Recommendation Report for Planning Permission for Works or Extension to a Dwelling

REF NO: LU/163/18/HH

LOCATION: 15 Parkside Avenue
Littlehampton
BN17 6BG

PROPOSAL: Garage extension/conversion.

18 / 4547 / 3

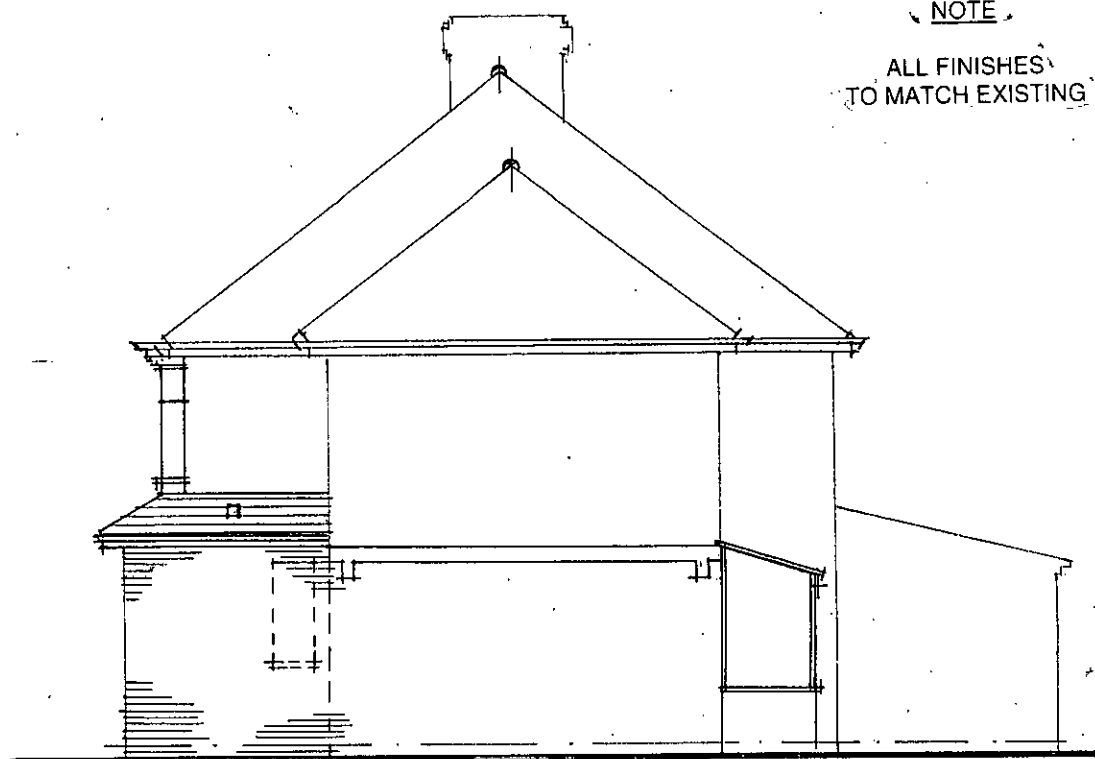
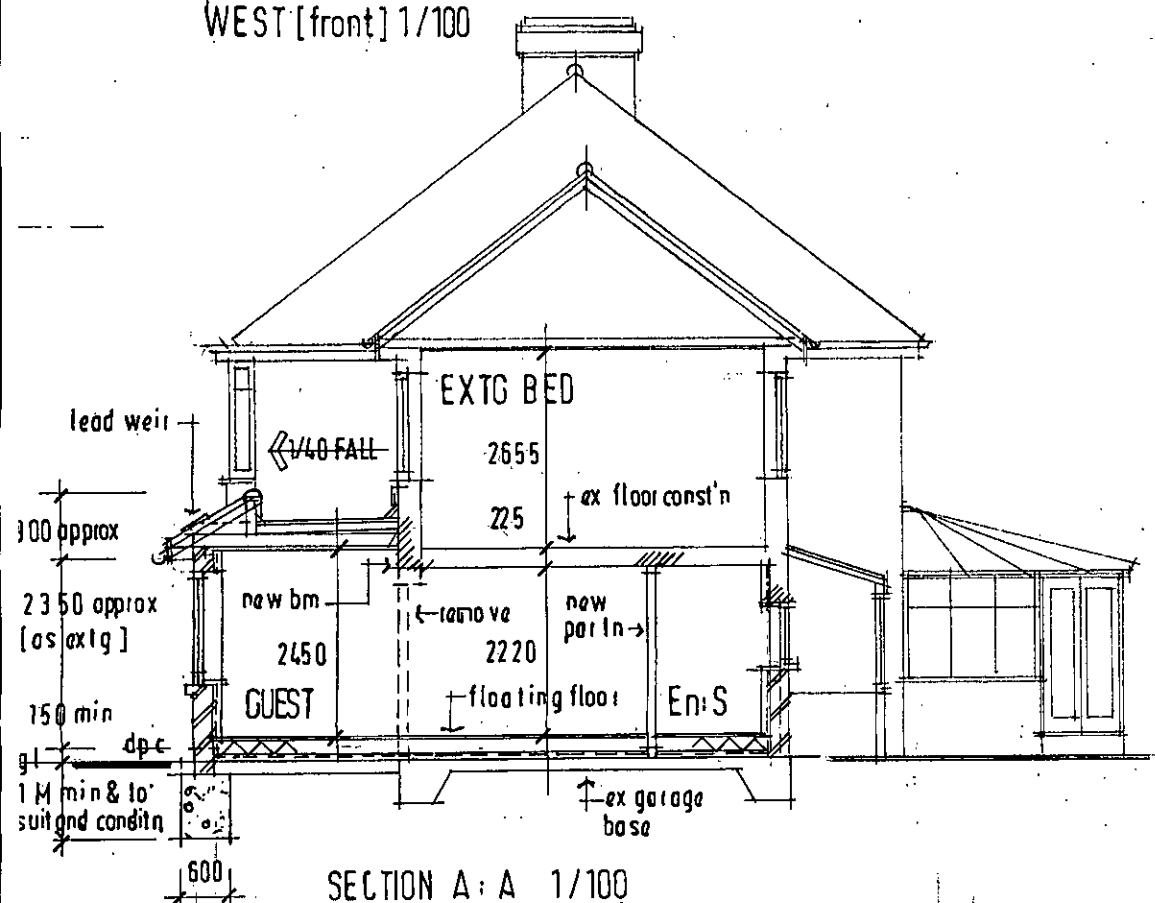
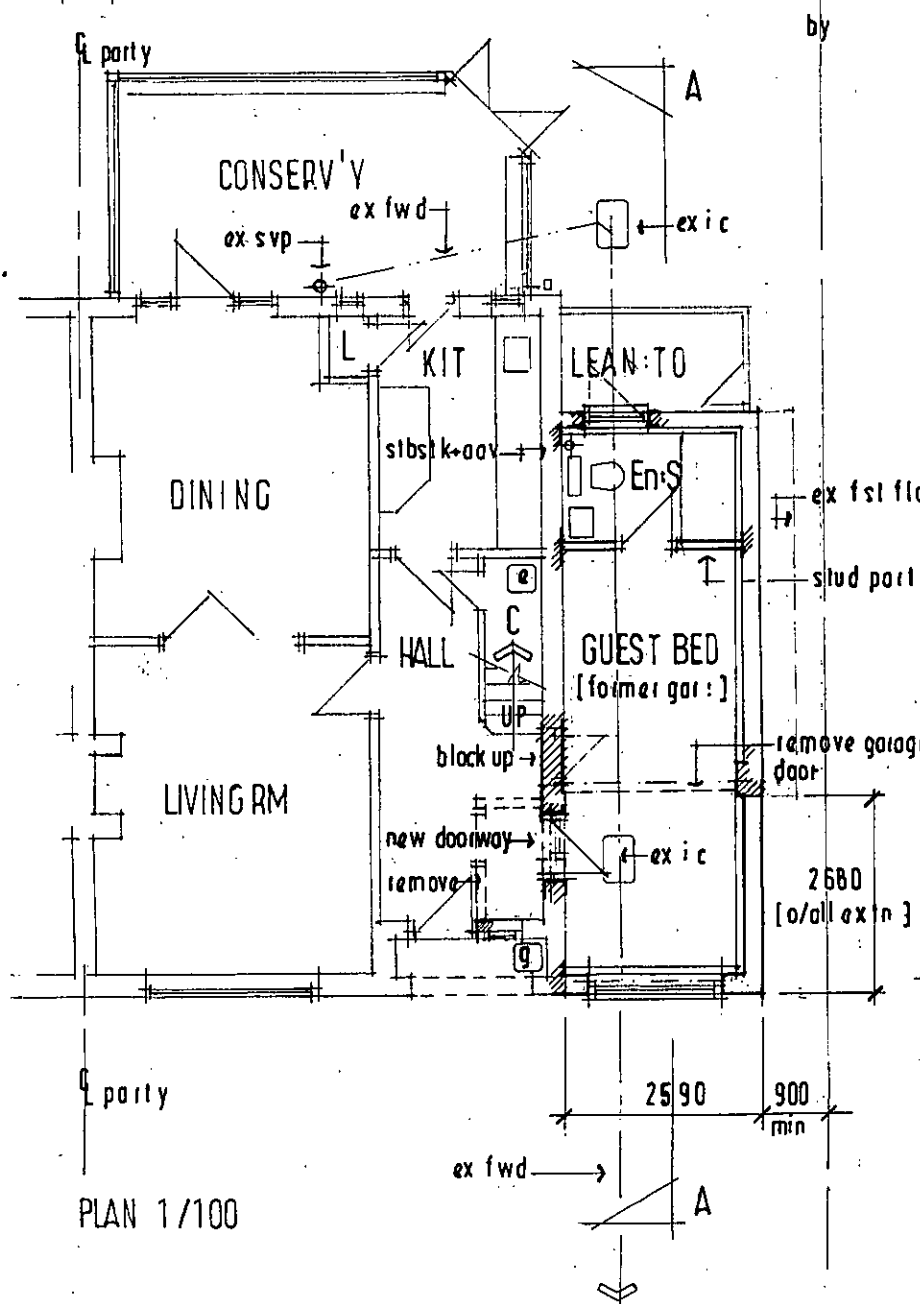
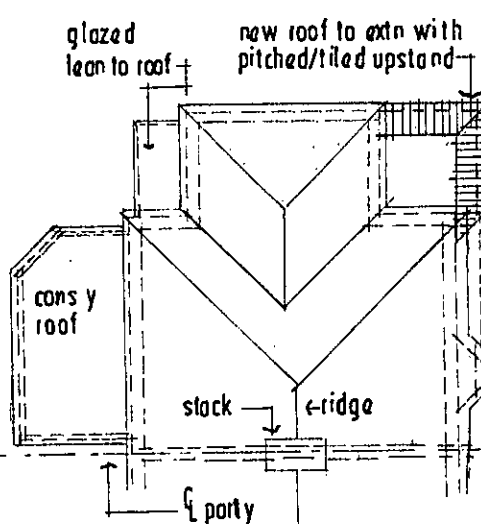
At present there is a side garage extension with bedroom above, which probably dates to the time the house was constructed. The front of the garage is currently set back from the front wall of the house (by 2.7m). The proposal is to add a single storey extension in this area, thereby removing the set back. This area together with the garage would become a guest bedroom with en-suite.

The roof of the extension would have a false pitch. The intention is that the finishes would match that of the existing house (brick & tile)

The property nearest (no.17) also appears to have converted its garage in the past. The proposed extension would not cause any material harm to the residential amenities of the adjoining occupiers.

In terms of parking the driveway is still available for the parking of at least one car. On street parking is also available.
